PLANNING DEPARTMENT – Development & Building Services

June 12, 2013

RE: **Zia Park Townhouse Apartments – Zia Road NE**
Grading & Drainage Plan for Grading and Building Permit
Tracts H & I, La Cuesta Subdivision

File **K22-D022D**
PE Stamp: 6/5/13

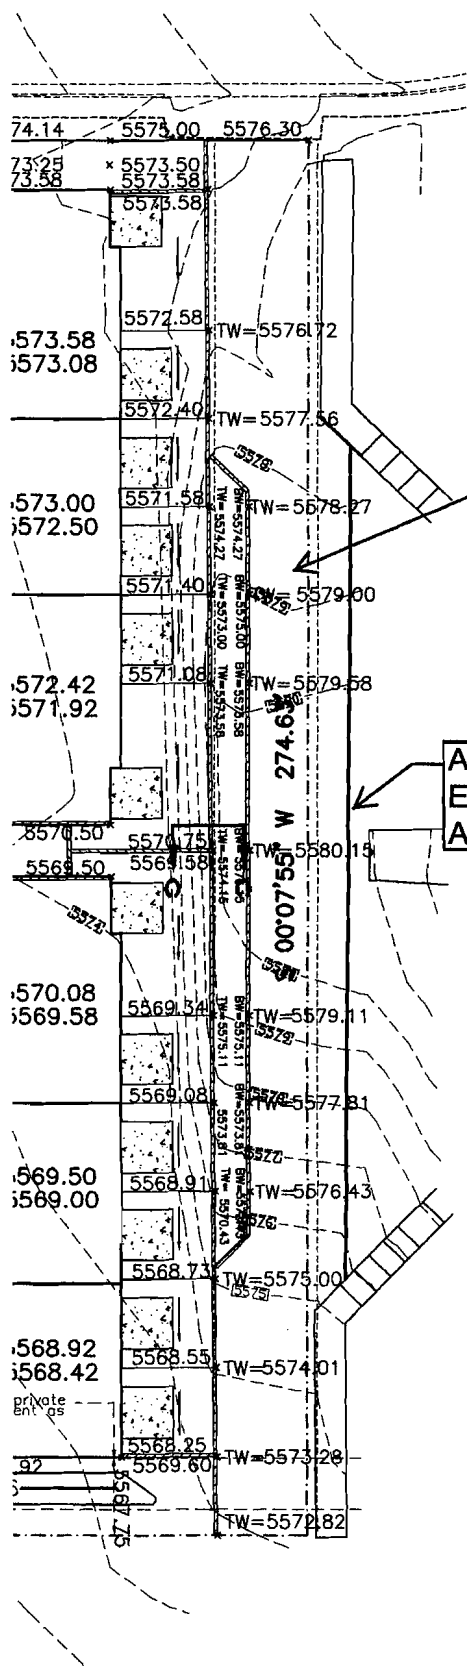
- b. The top of wall detail appears to allow pavement runoff to overtop the wall and flow into the site/back yards. This is not acceptable. This section needs to show how drainage will be kept in the roadway, directed away from the retaining wall and yards below it. Increase the top of wall and/or swale the pavement section to divert flows to appropriate outfall locations.

- c. **NEW:** I noticed in our files that the approved Traffic Circulation Plan submitted by Cinelli Architects, shows (in his Build Note 22) a “*New Retaining/Garden Wall - Minimum Wall Height - 42” Above Road Grade*” at the western edge of the mutual access easement. Your wall and paving design section should be coordinated with that condition.

ENGINEER'S SEAL 	ZIA PARK HOMES GRADING AND DRAINAGE PLAN Rio Grande Engineering 1806 CENTRAL AVENUE SUITE 201 ALBUQUERQUE, NM 87106 (505) 872-0999 MAY 2013	DRAWN BY WCMJ DATE 5-07-13 2721-LAYOUT-2-05-13 SHEET # JOB # 2721
---------------------	--	---

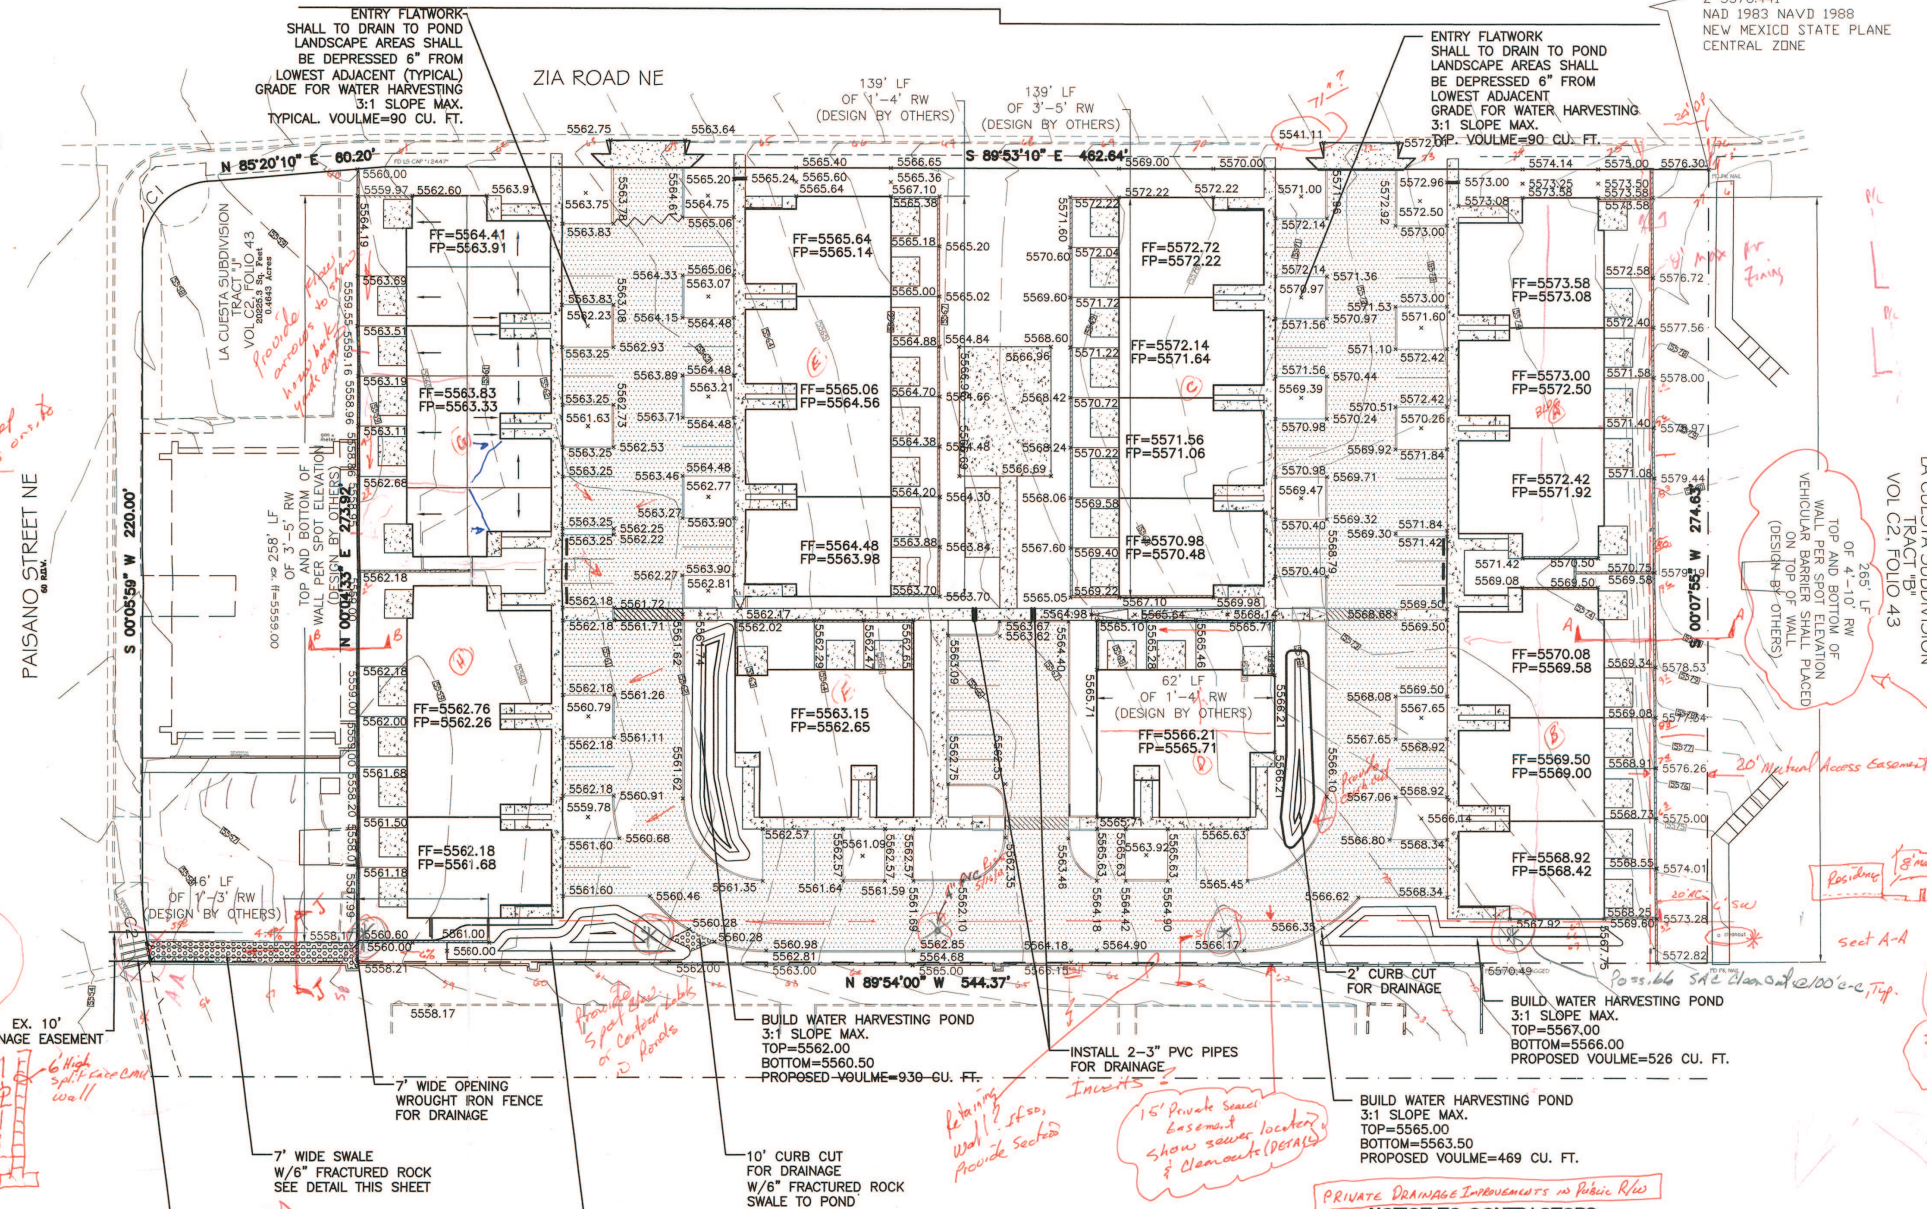
1. The sanitary sewer note (No. 4) needs to be clarified to state that any cleanouts located within ponding areas must be relocated “outside the ponding area.”

2. Clarify with flow arrows on plan, or typical section, that drive lanes are cross sloped.
3. Provide a curb cut to allow street flows to enter the eastern water quality/harvesting pond on the north side of the “U” drive (SE of Bldg. D). Show with flow arrows, how the water is directed into or through this area.

4. Regarding the existing paved roadway and proposed, terraced, retaining walls along the eastern boundary of the site:
 - a. Section C-C is mislabeled (A-A) and is reversed from the direction cut on plan.

- d. Clarify drainage patterns with flow arrows on the paved area.
 - e. The 6’-high terraced wall section does not appear to extend far enough north and south to support the shown grade differentials where they are greater than 6’.

5. Regarding the outfall channel at the SW corner of the site and crossing Tract J:
 - a. Is the 6" Fractured Rock Swale 6" thick? What is the rock gradation?

6. Regarding the Sidewalk culverts on Paisano Street:
 - a. Provide details of the concrete transition structure necessary between the trapezoidal, Rock Swale and the two, rectangular, 24" Sidewalk Culverts.

- b. Extend the sidewalk culverts at least two feet back of sidewalk, unless the hydraulic transition feature above, provides some alternate, drop-off safety at the upstream edge of the culverts.

7. Make corrections to numerous typos in the "Notice To Contractor" section, for the construction of "Private Drainage Improvements in Public R/W."
8. The 5560 contour near the SE corner of the largest/main pond is very close to the existing 5562 contour crossing the existing, south wall footing. Ensure that this pond does not undermine the existing wall. If revised contours significantly impact the pond volume, please submit updated, pond volume calculations.
